Your Reference: TR030003
**Our Planning Inspectorate
Reference:** 20010091
Our Internal Reference:
DCO/2017/00001

06 July 2018

**RE: TILBURY2 – SECTION 89 AND THE INFRASTRUCTURE PLANNING
(EXAMINATION RPROCEDURE) RULES 2010: EXAMINING AUTHORITY’S “RULE 8
LETTER”**

SHEET 3 OF WORKS PLANS

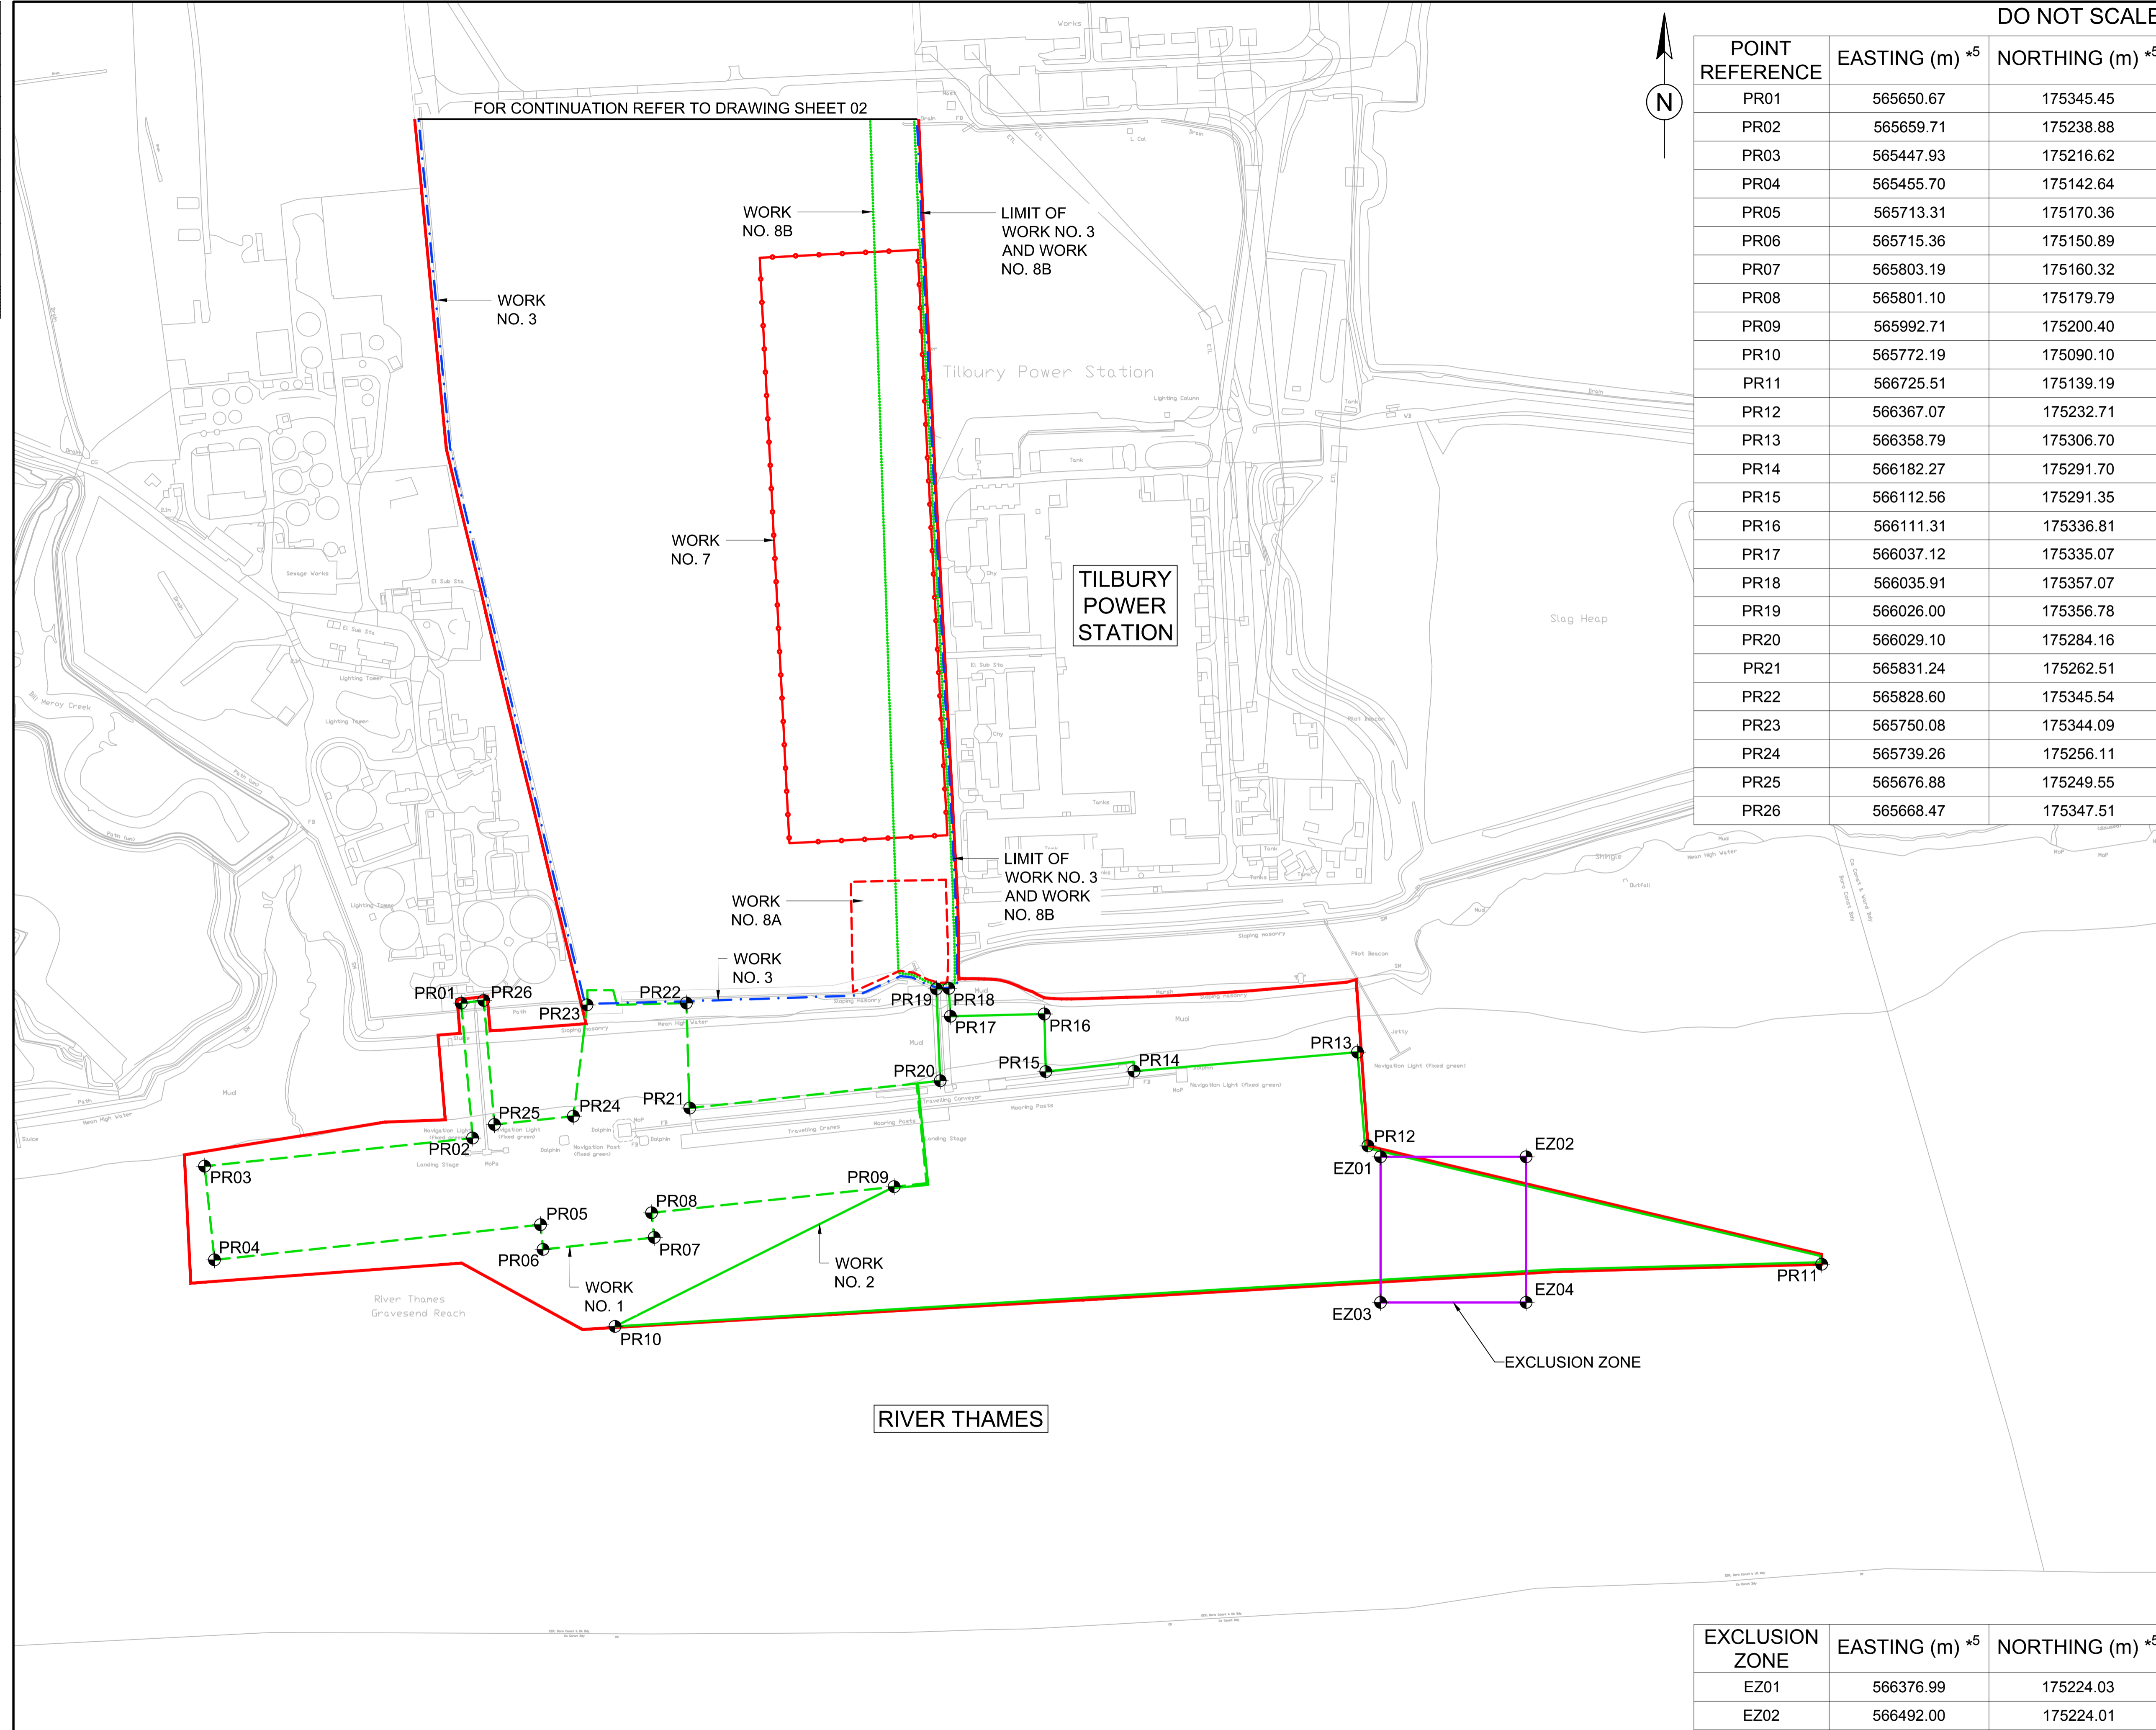
2.4.3. Under section 3(4) of the DML, we recommend replacing the wording "No water injection dredging" with " No hydrodynamic dredging", as the supporting documents, including the CEMP, do not state that water injection dredging is the only method of dredging that will be undertaken outside the exclusion zone.
